CITY OF ALBUQUERQUE

August 28, 2019

RE: **Winrock Regal Cinema Temporary Parking
Amendment to Road B Extension
2100 Louisiana Blvd NE
Grading and Drainage Plan Stamp Date: 8/21/19
Hydrology File: J19D058H**

Based on submittal received on 8/22/19, the Grading and Drainage Plan cannot be approved until the following are corrected:

DRAINAGE PLAN

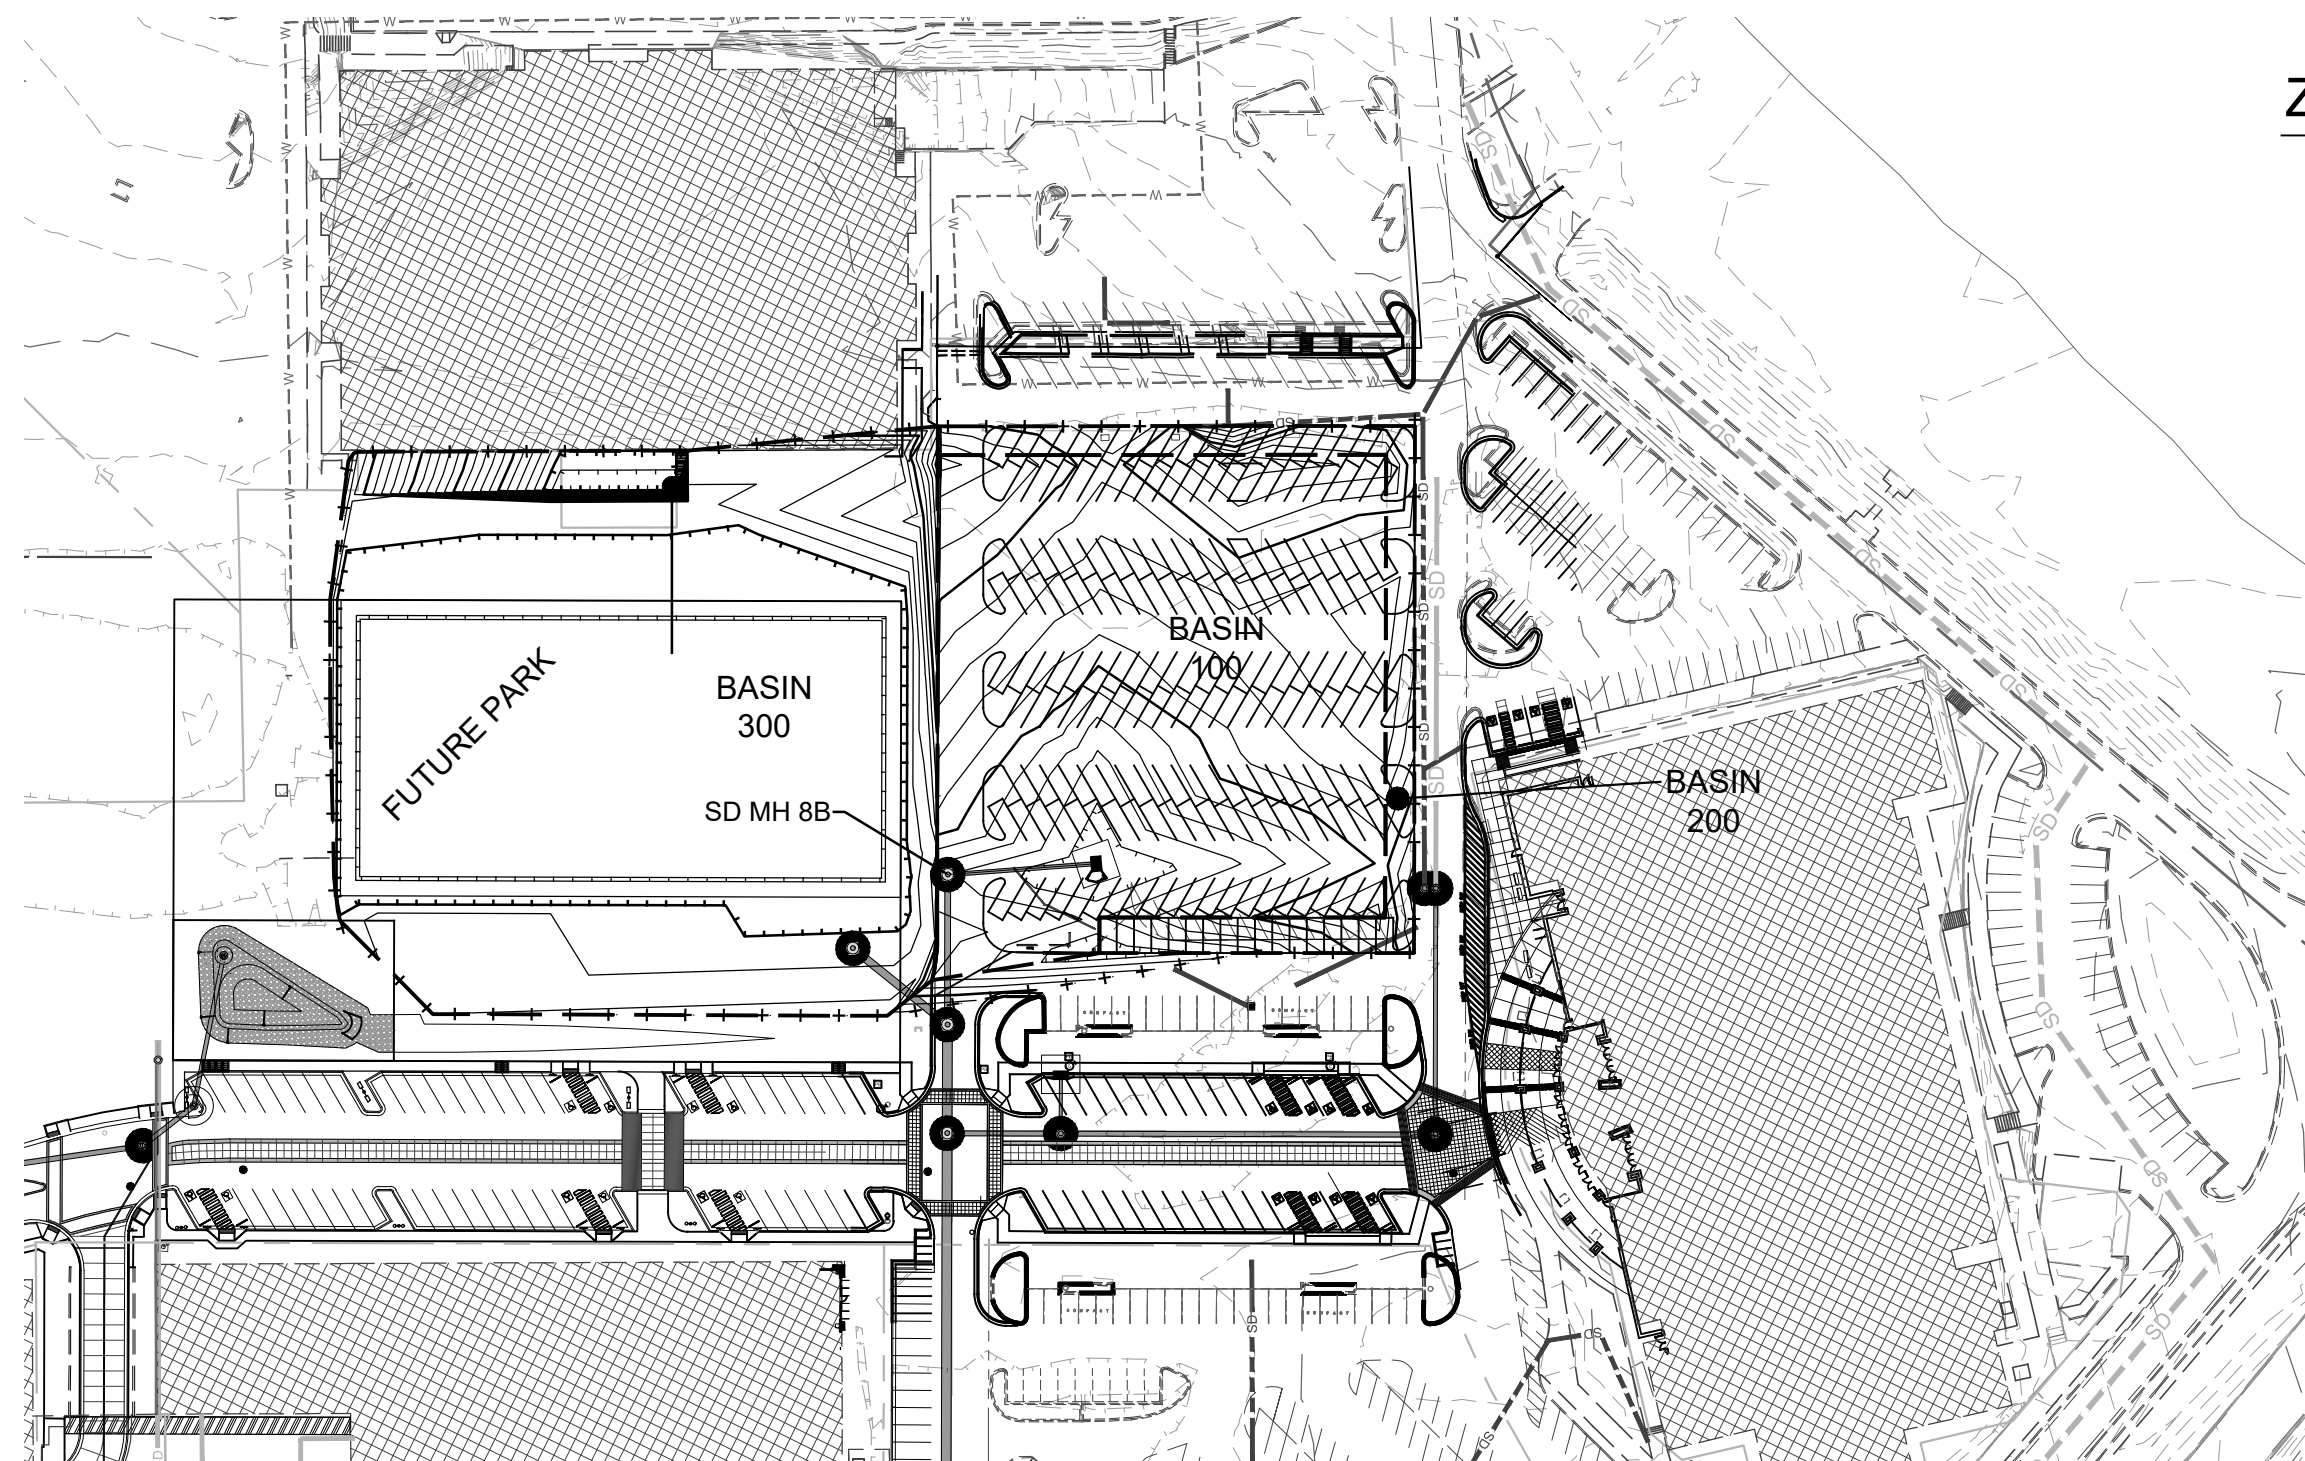
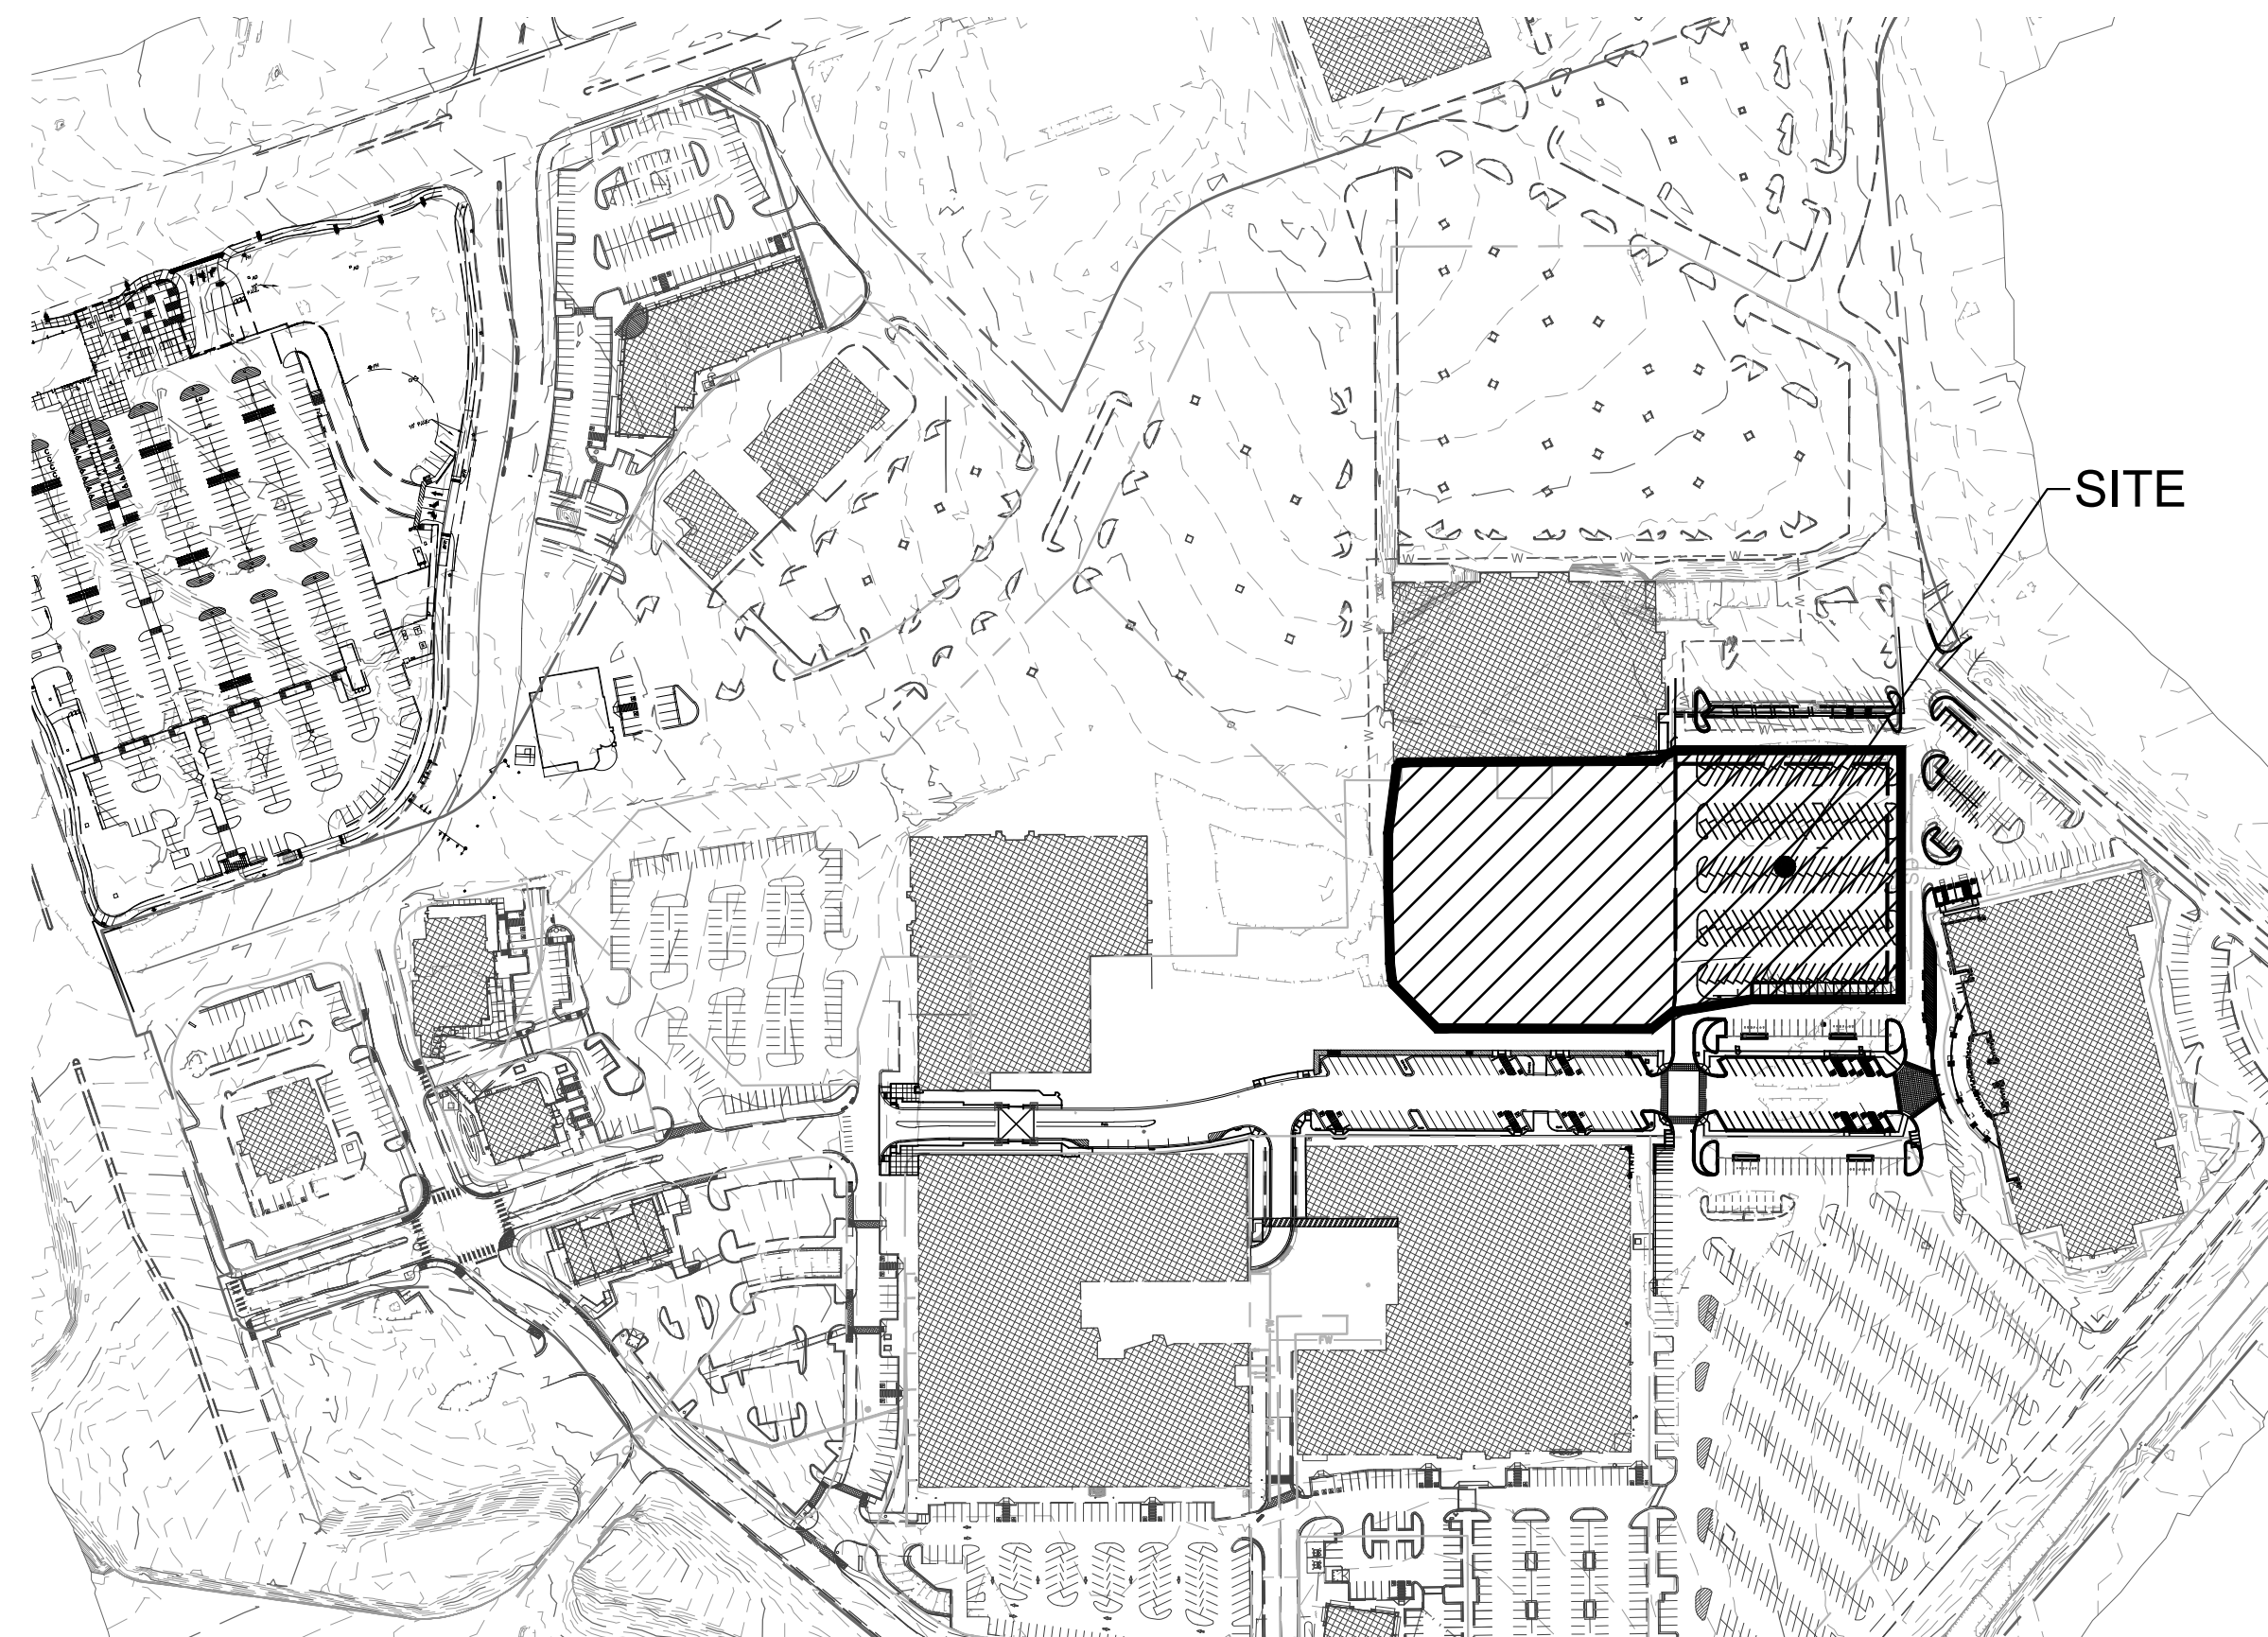
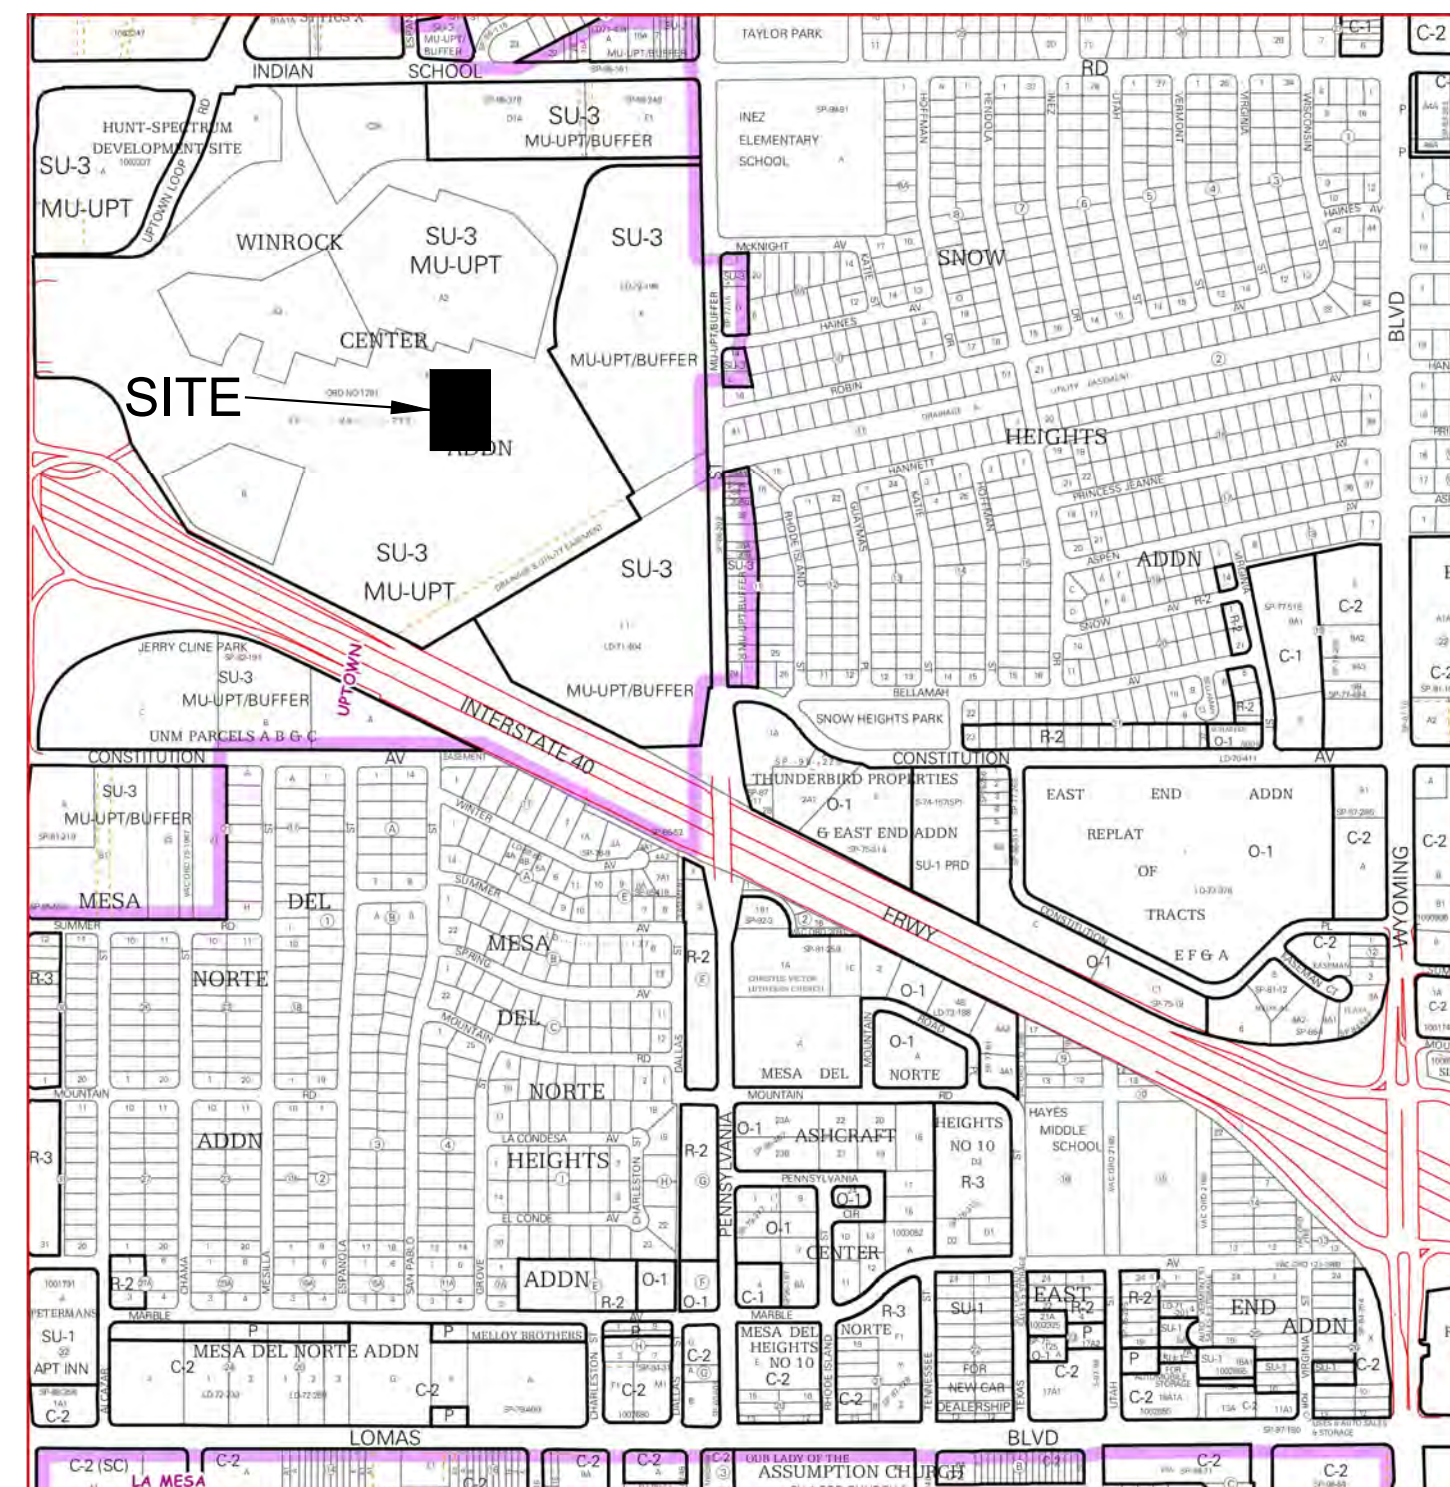
1. Show all proposed (temporary) grading in the future park area; the site is being graded now and we need a plan for it (§ 14-5-2-12-B-4).
 - a. Provide temporary ponding for the 100-yr volume.
 - b. Special care needs to be taken with respect to grading around the adjacent buildings to prevent water from entering them. Notably, Dillard's has a finished floor of 5294.4', but surrounding grades are ~5298'.
 - c. Add callouts as necessary that grading is temporary and will be revised when the park is constructed.
2. Construction notes 3 and 4 need to be swapped.
3. For Information. The ponds being proposed will need to be surveyed, certified, and inspected as part of the Work Order close-out.
